**Preferred Project Report
'Stage 2' Residential Development - Buildings 6, 9 & 10
61 Mobbs Lane, Epping (MP11_0048)**

Attachment 1

Dec 21, 9am (Daylight Saving)

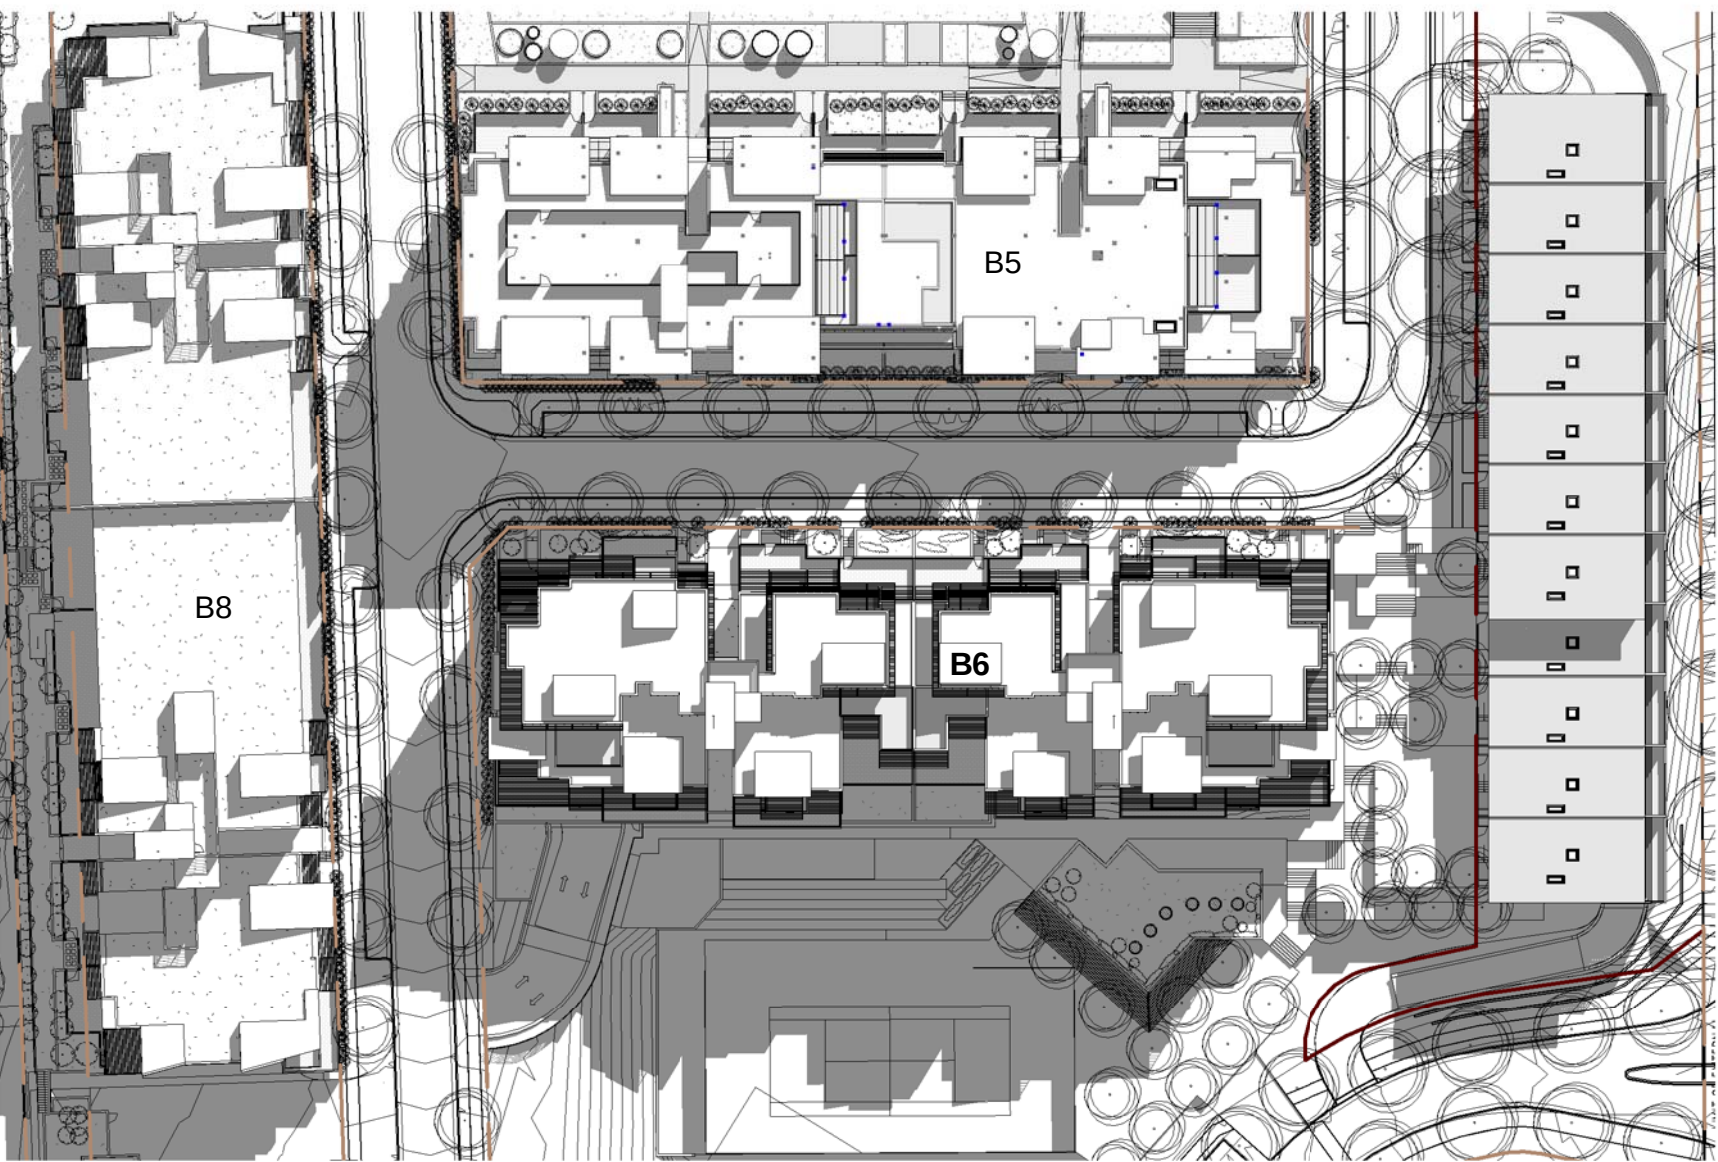
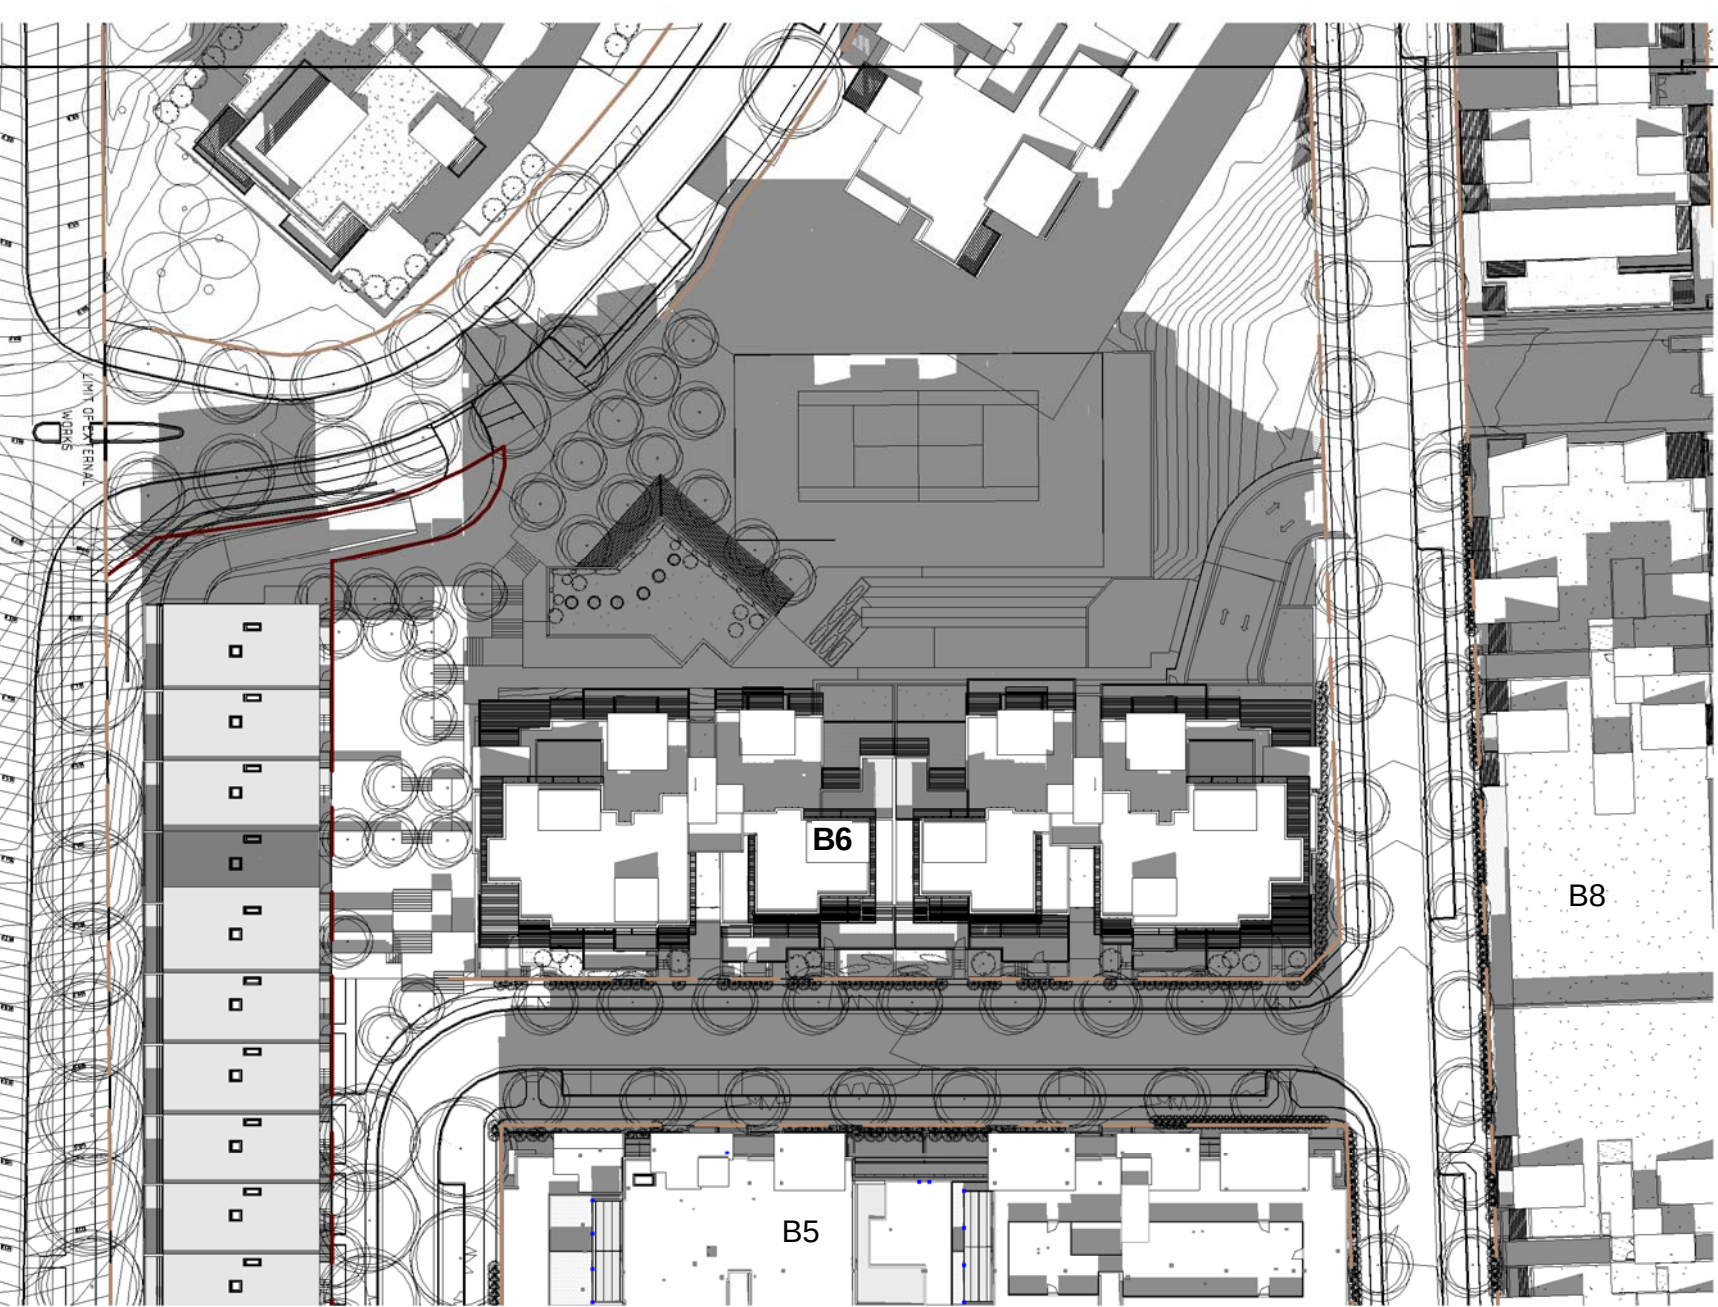
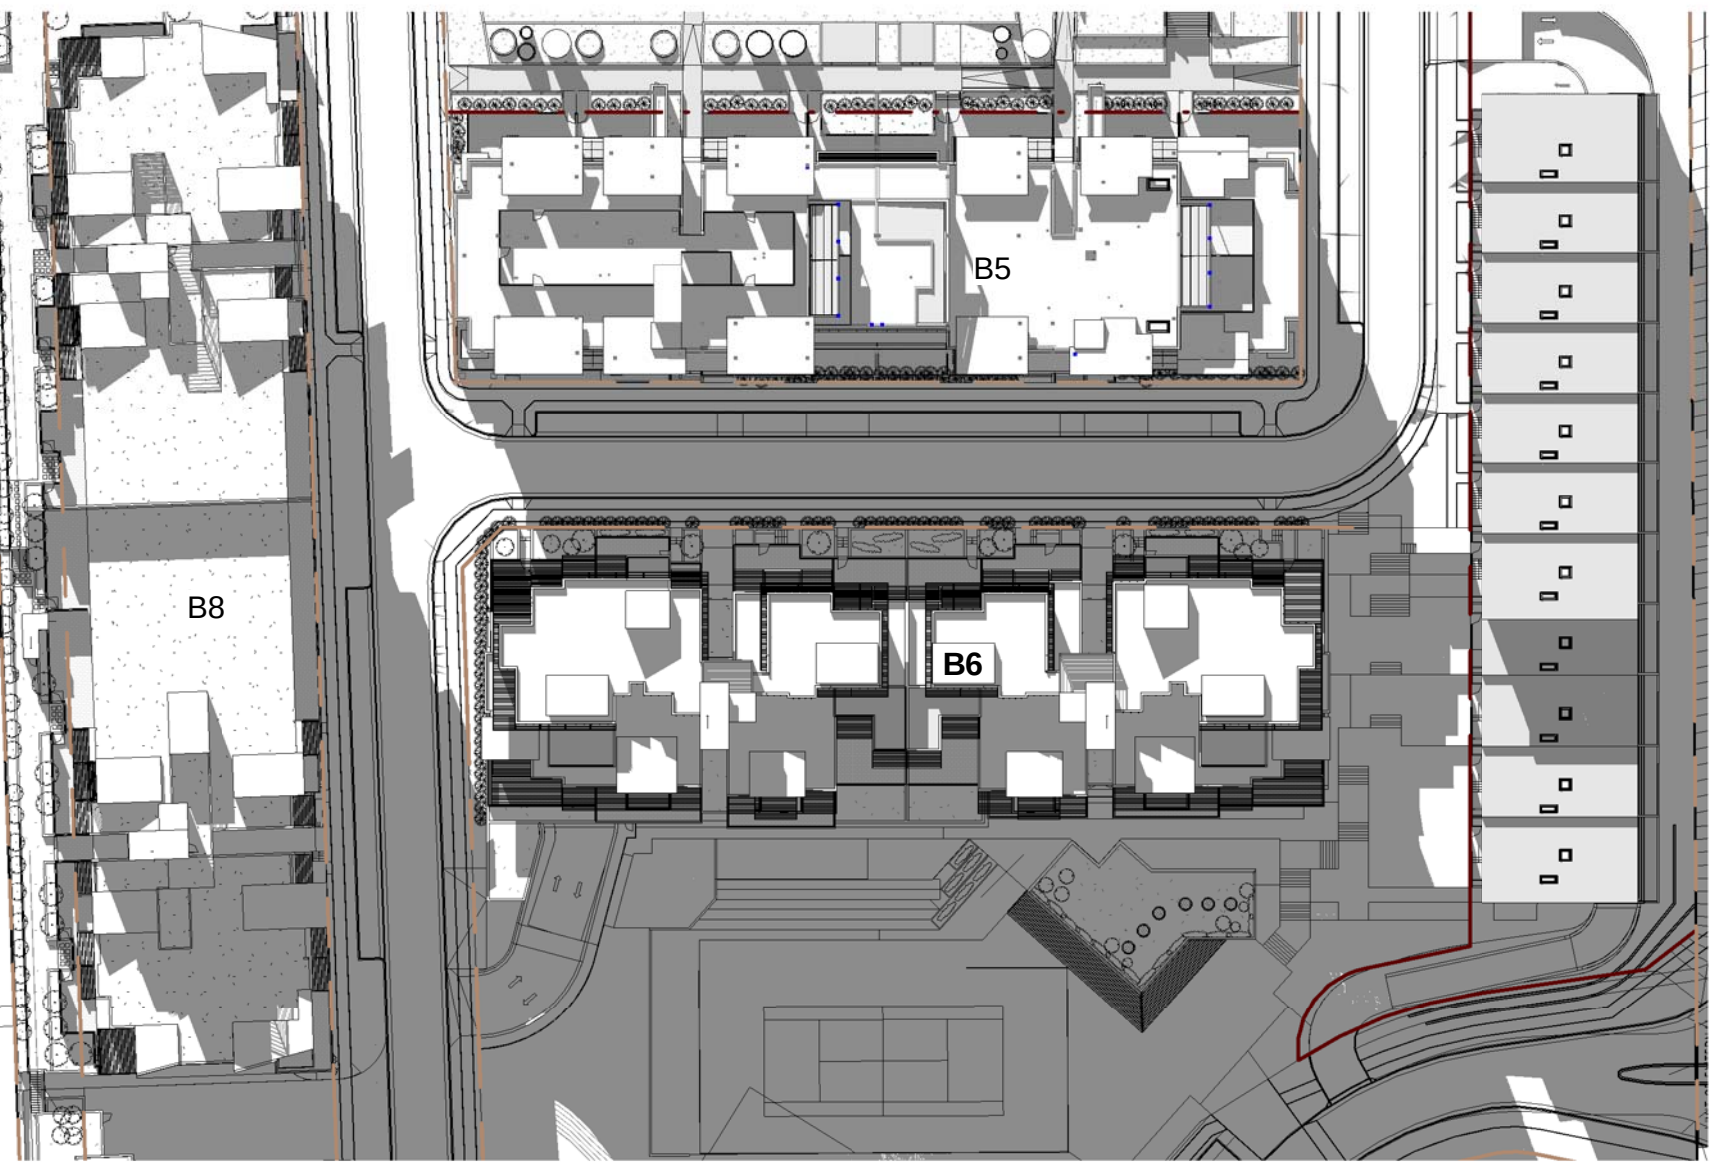
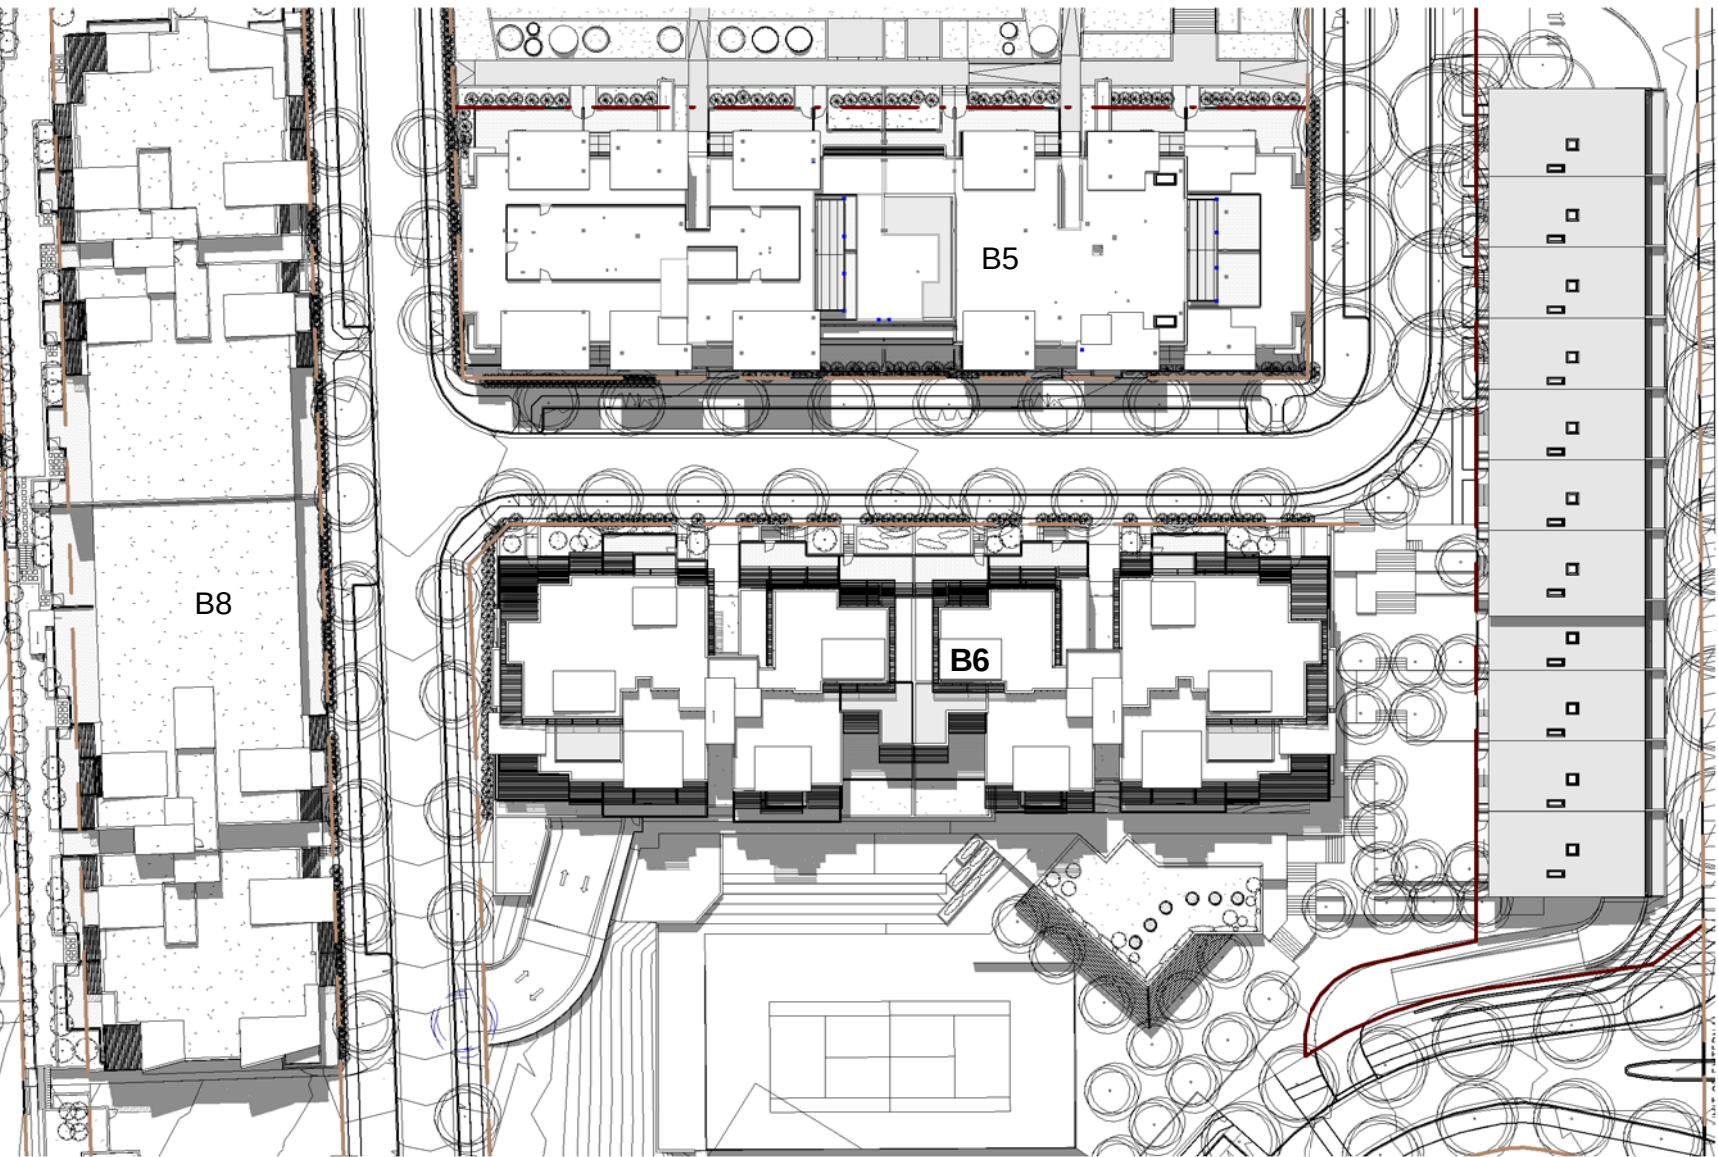
- the south-east elevation shall include ground level detail between Building 6 and Building 2 to illustrate the natural/future ground level at pedestrian level
- plans shall more clearly illustrate elevational treatment at pedestrian level at the south-west corner of the building
- further annotation in drawings A0612 and A0621 is requested for the retaining wall/landscaped area between Building 6 and the tennis court. Further detail is required for the car park entrance and driveway
- shadow diagrams shall be amended to include the tennis court
